V2_Sketch Plan.pdf Markup Summary

Subject: Text Box
Page Label: [1] SKP
Author: CDurham
Date: 1/10/2024 1:15:55 PM
Status:
Color: ■
Layer:
Space:

SKP235

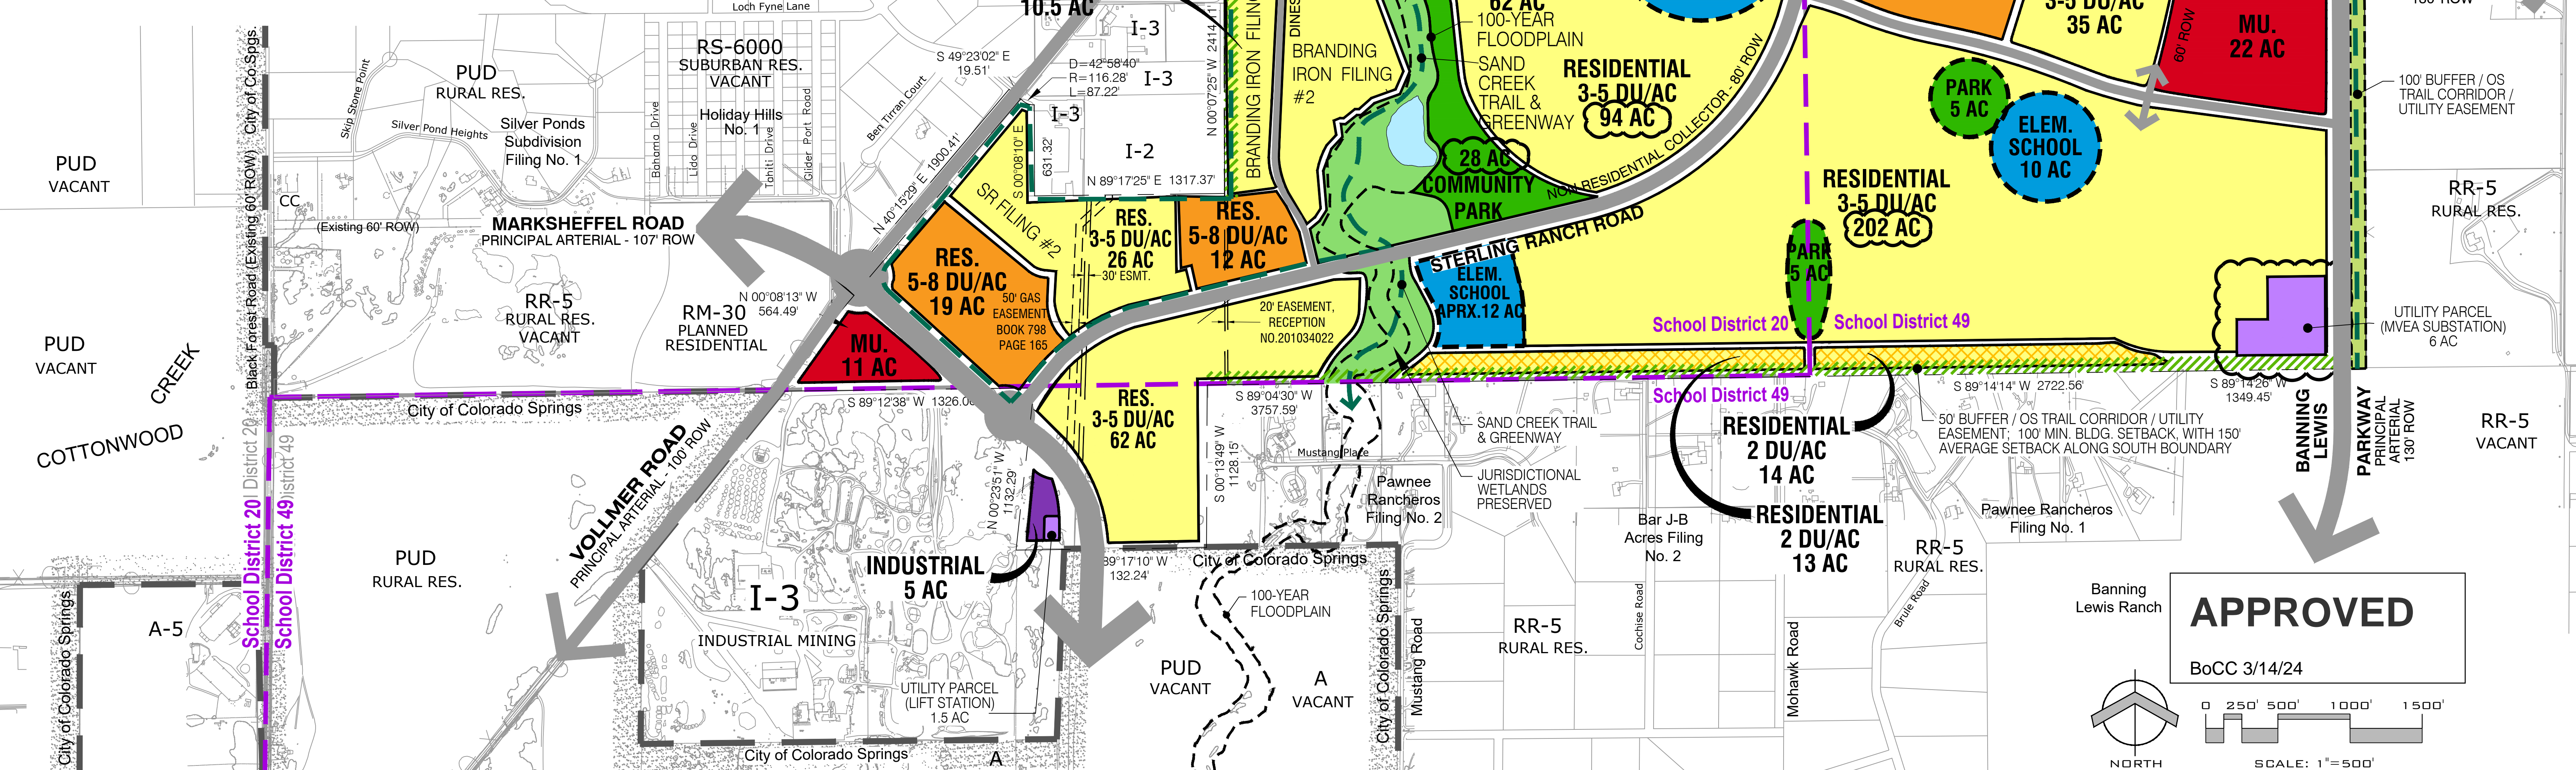
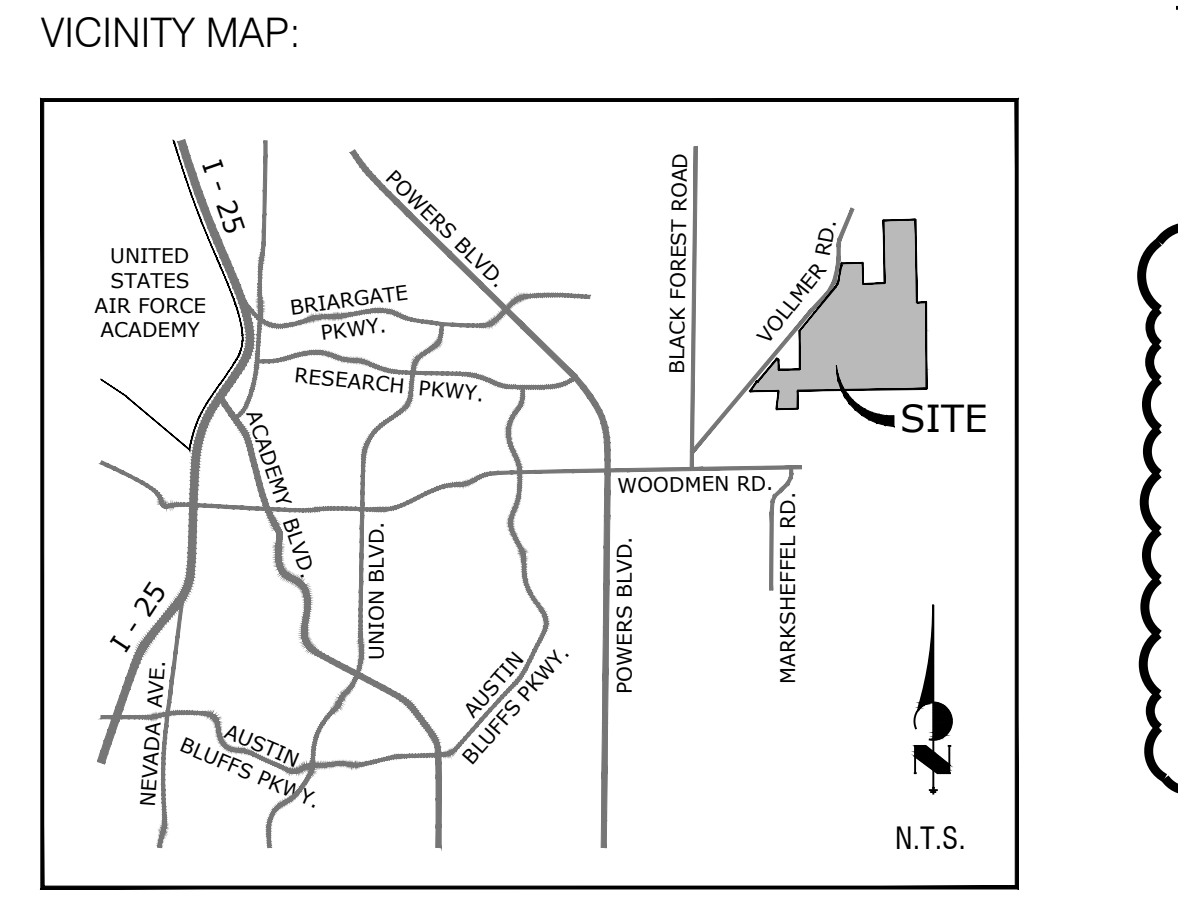
Add condition of approval (See SKP224 condition #1) that max number of dwelling units to remain at 4,800 lots, as agreed to per previous amendment.

review 1 comments not addressed add a approximate total of acres -legal for area being amended in addition to the original legal staying; i should state that x of the 1443.695 acres is proposes to be amended

Complete Sketch Plan Legal

Area Being Amended Description or total

Please add missing checklist items. I know you are using the old map but please bring the amended areas up to depict the checklist requirements as posted to website below. To the left are snippets. The checklist is on our website for a complete checklist

for review 2 missing sect township range county state in title as mentioned in review 1 to the left

this will go to PC and BOCC so delete- a resolution will be recorded
